**RESPONSE TO REQUEST FOR ADDITIONAL INFORMATION
SSD-11429726 – EDEN STREET COMMUNITIES PLUS**

This letter has been prepared by Ethos Urban on behalf of Arncliffe Eden Property Pty Ltd in response to the Request for Additional Information (RFI) issued by the Department of Planning and Environment (DPE) for SSD-11429726 dated 4 April 2022, as well as additional requests for clarification received by email. This letter should be read with reference to the following appended documentation:

DRAWING NO.

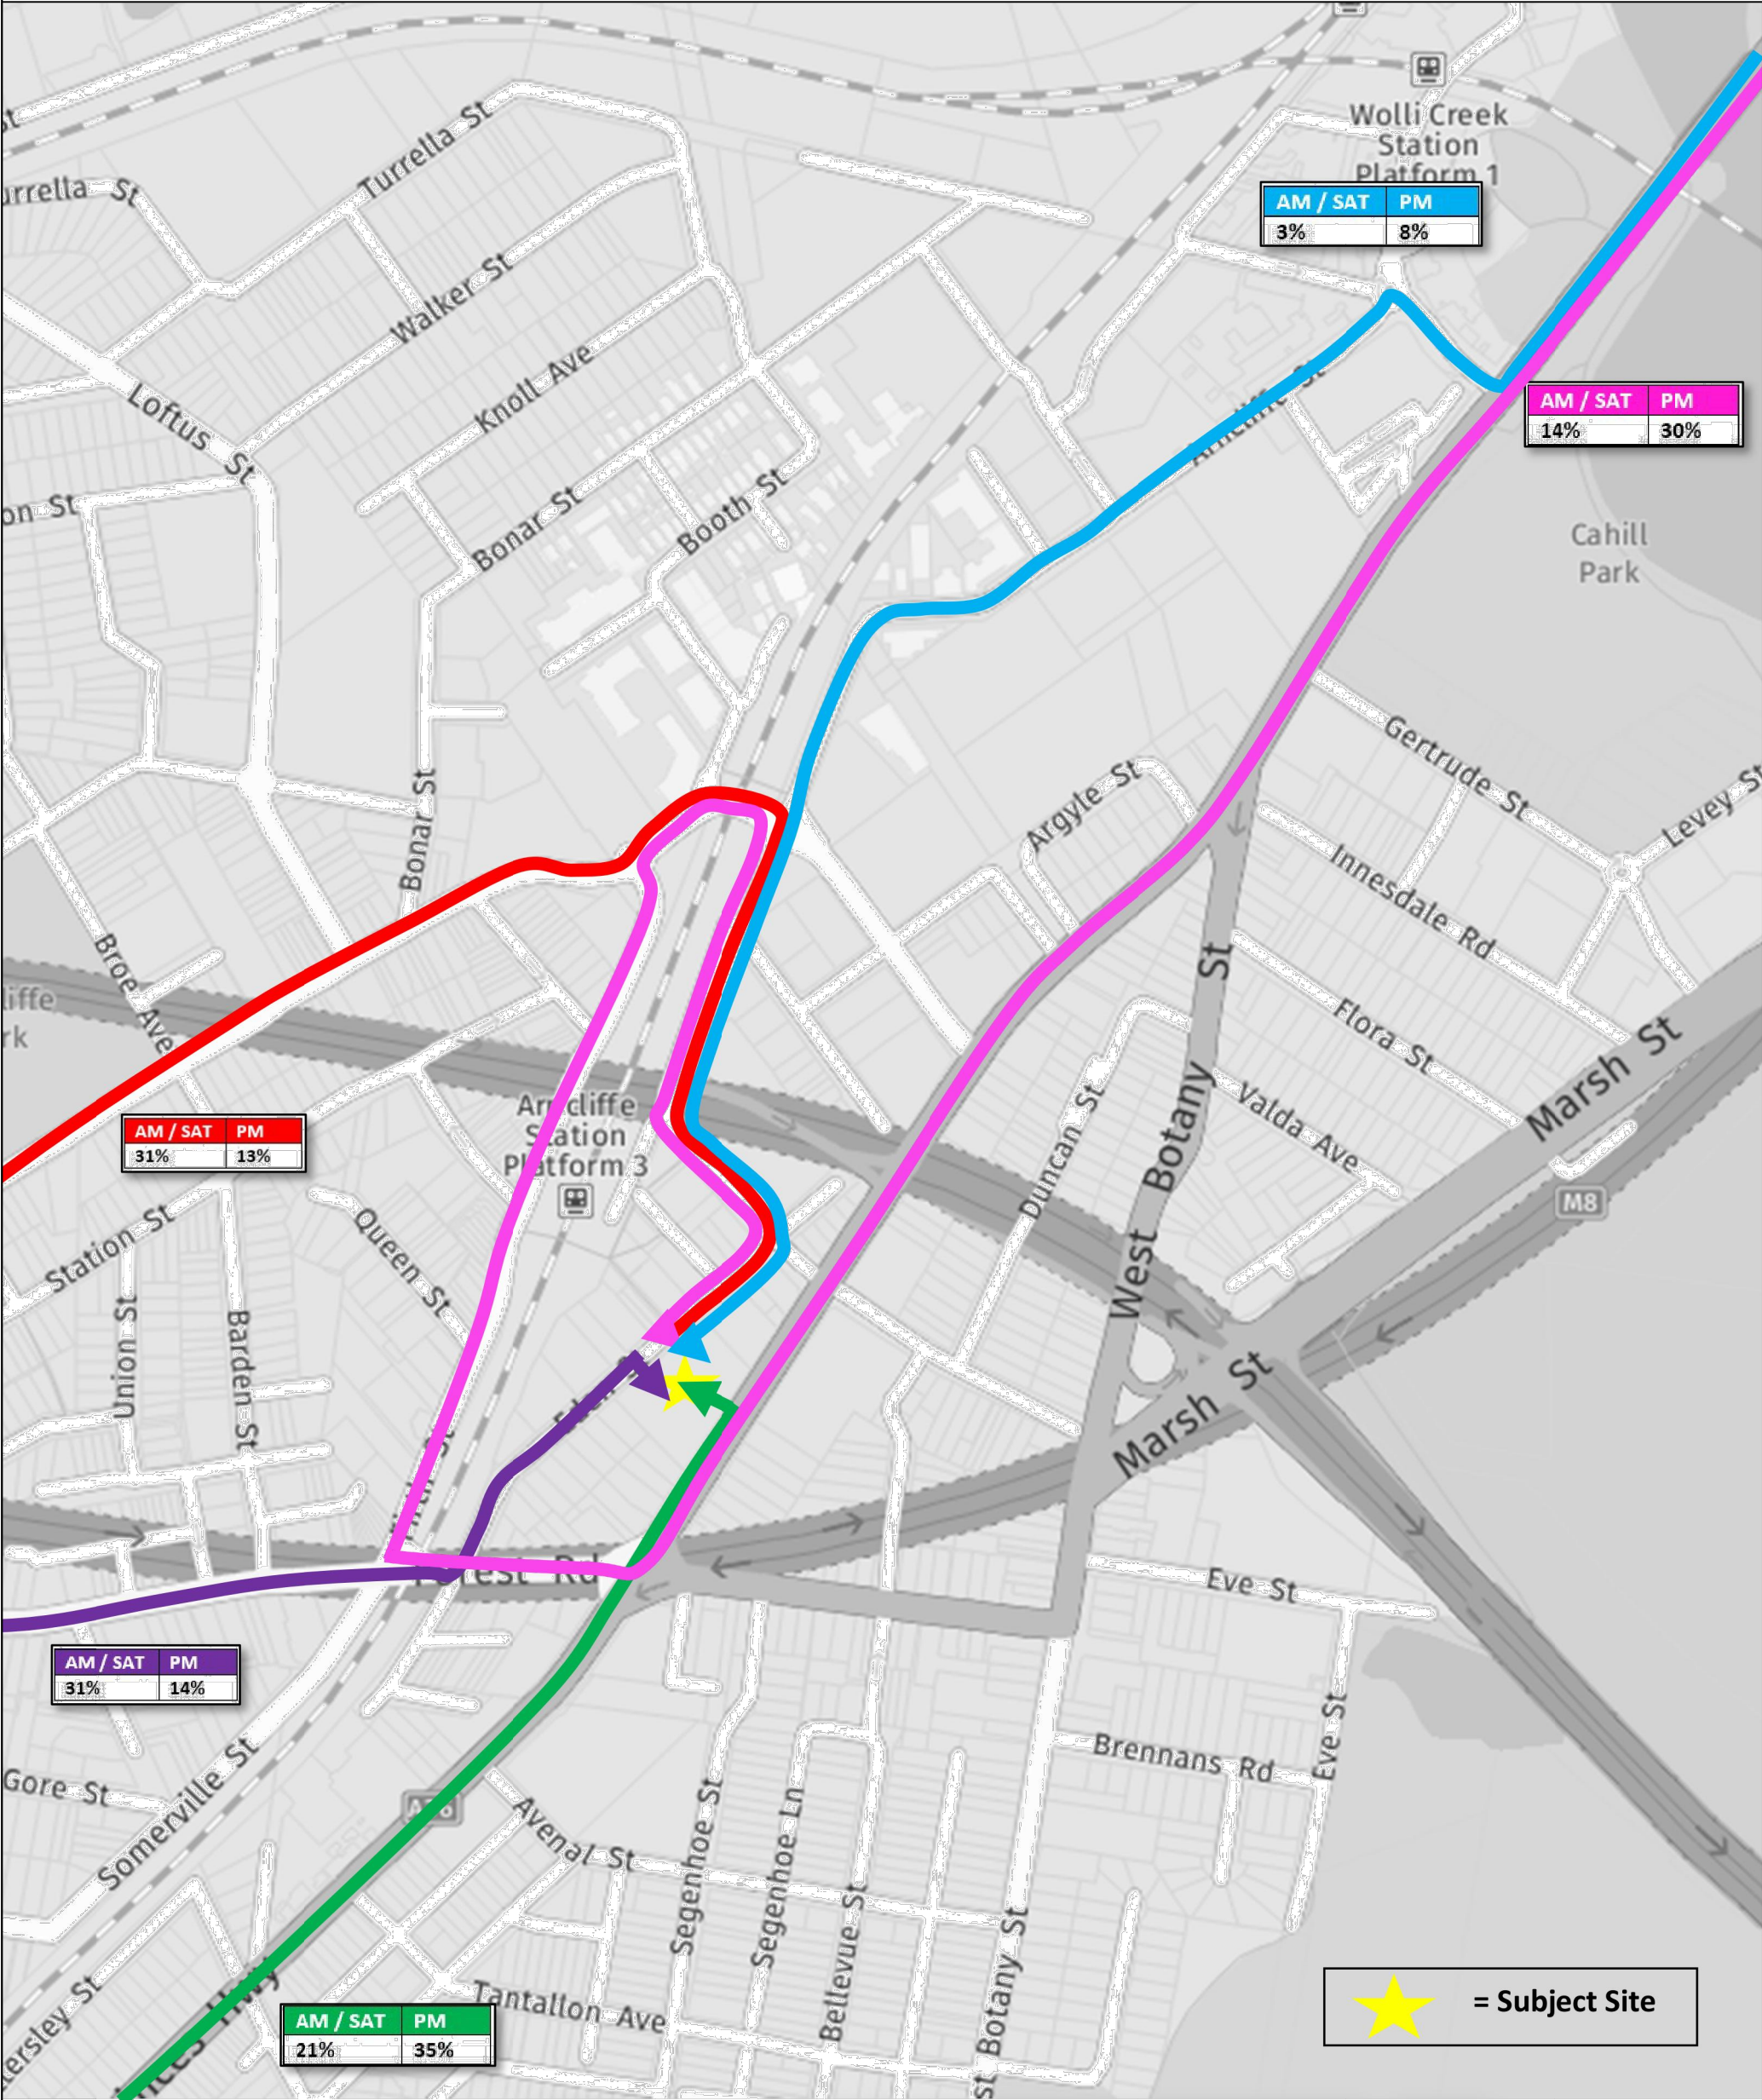
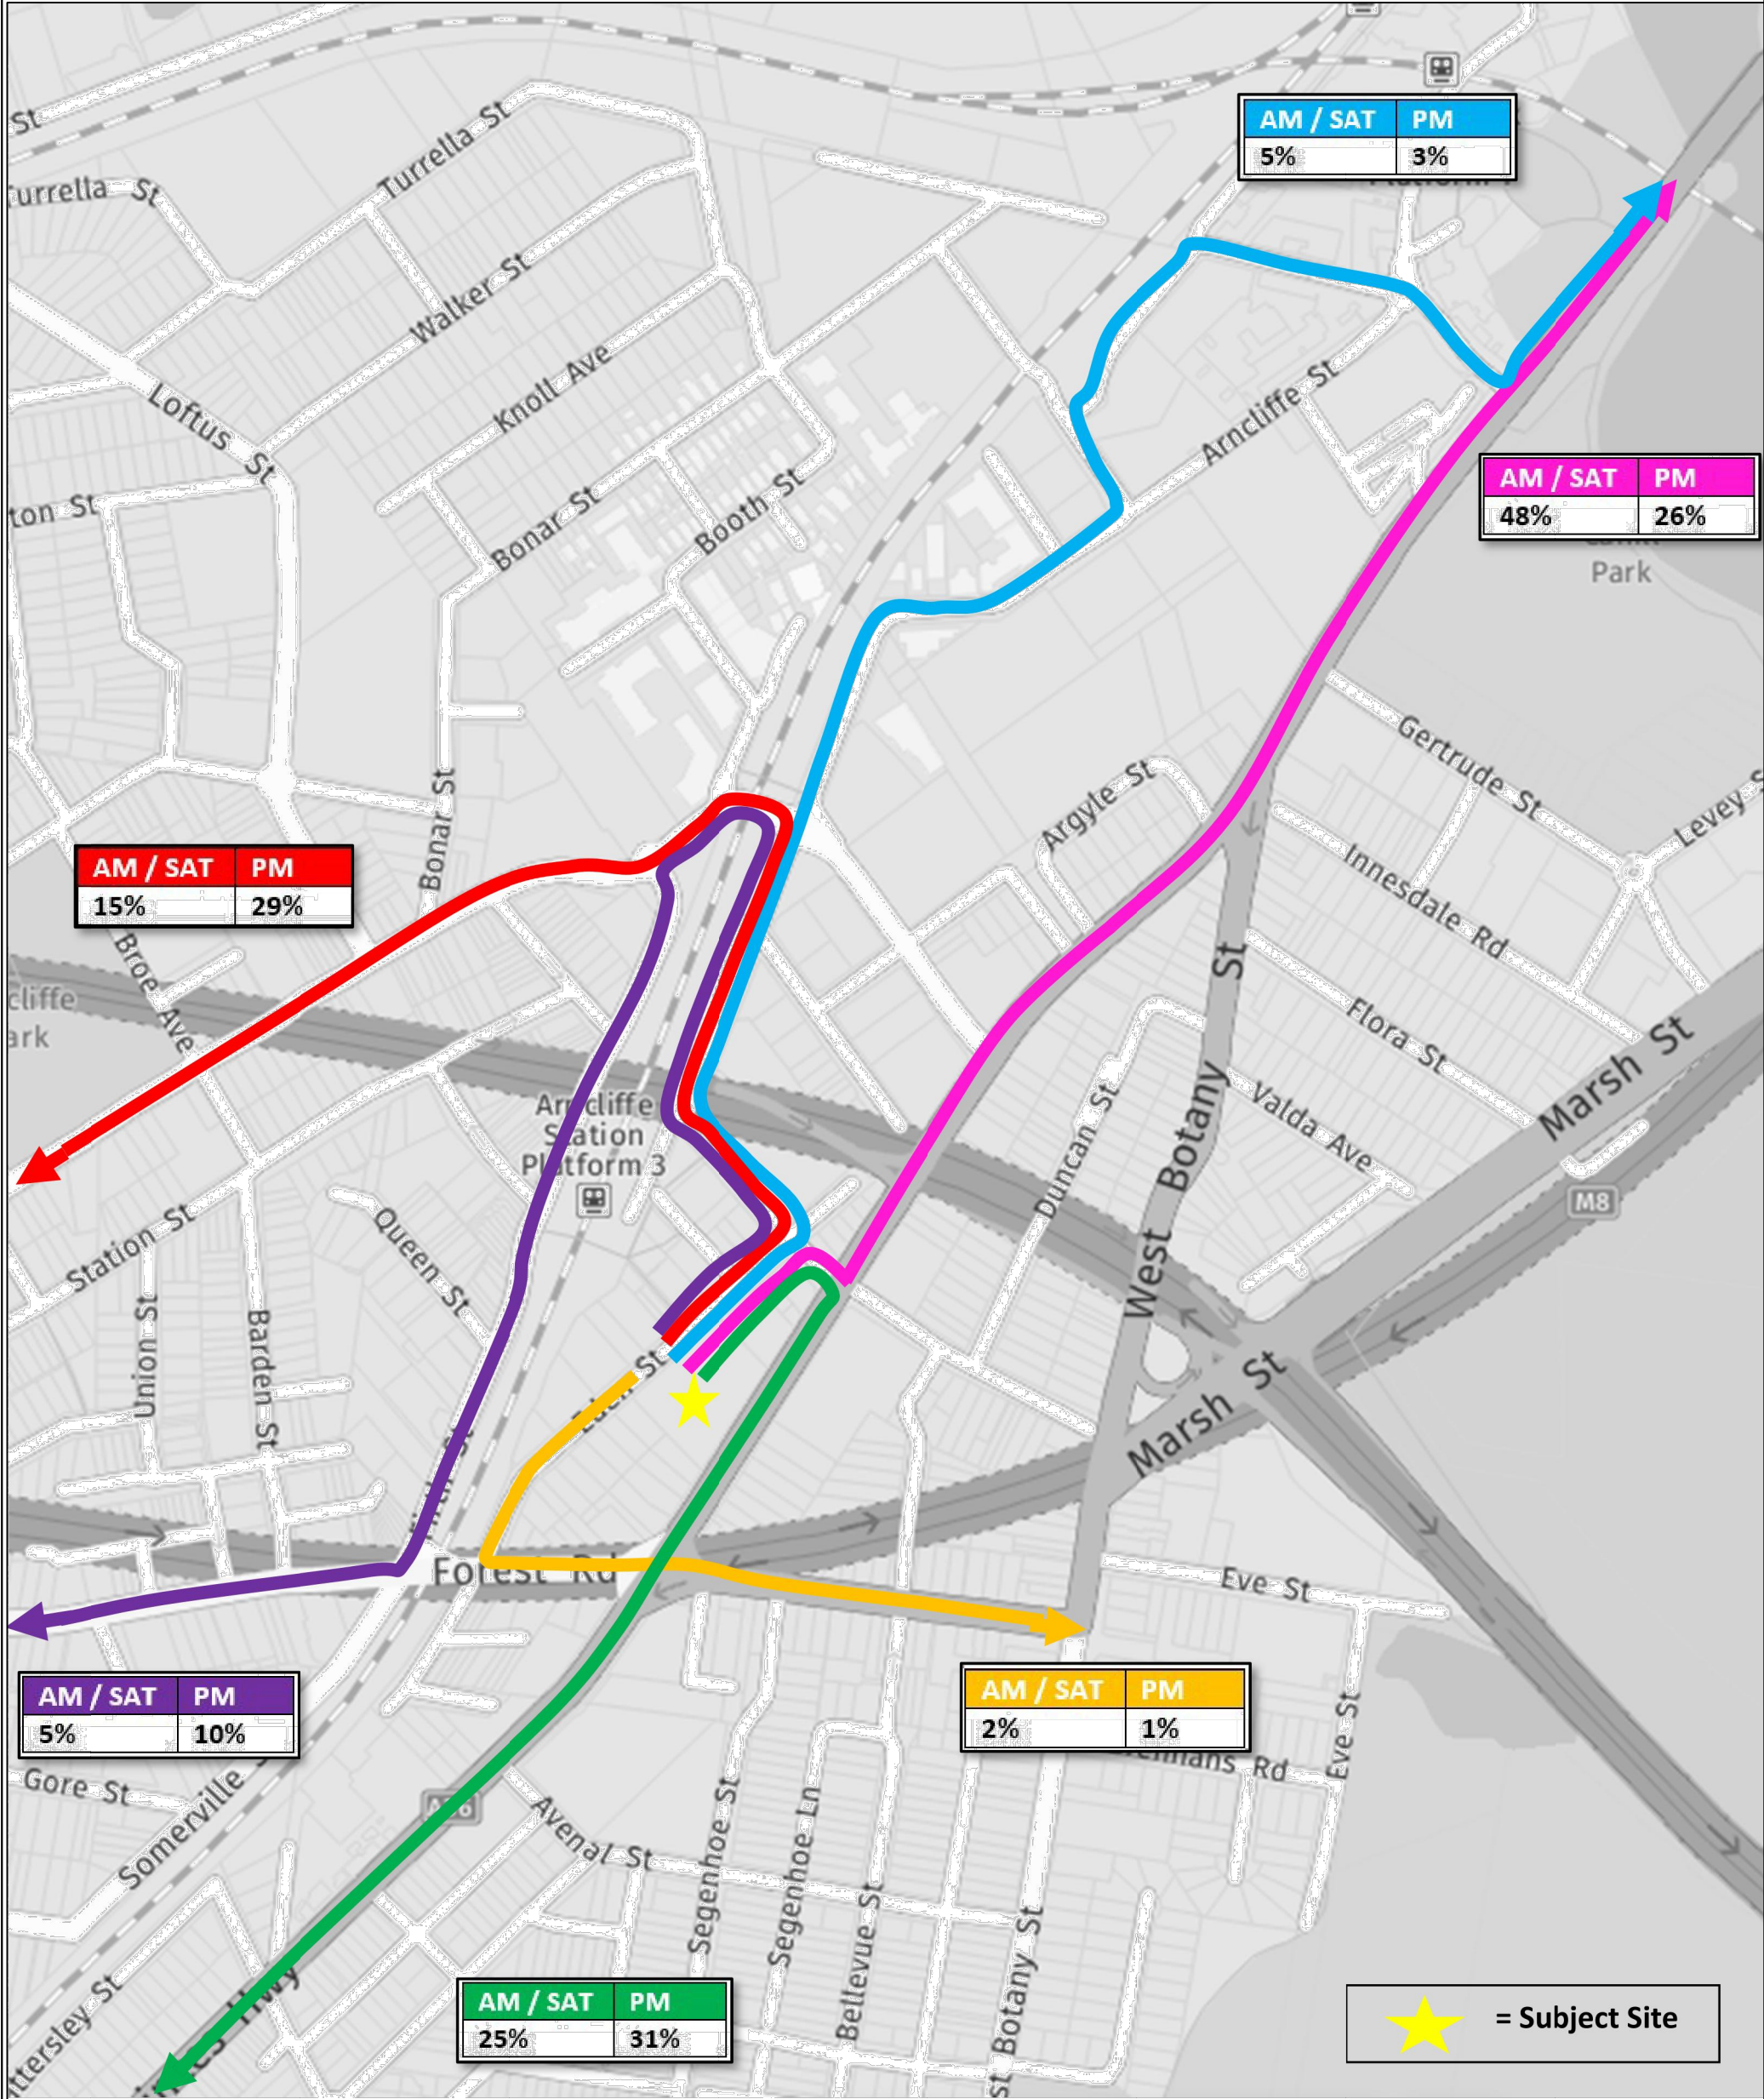
<ul style="list-style-type: none"> EES group comments of 24 February 	<p>A detailed response to comments raised by the EES Group have been provided by Group GSA at Attachment B. The response confirms that Tree 109 is to be retained and protected as consistent with the advice of the Birds Tree Consulting Arborist Report which was submitted as Appendix H of the RTS dated 8 February 2022.</p>
<p>Please also correct the errors within Attachment D to confirm the combined vehicle trips.</p>	<p>Amended Intersection and Route Diagrams have been prepared by Stanbury Traffic Planning at Attachment C rectifying errors in the submitted documentation.</p>
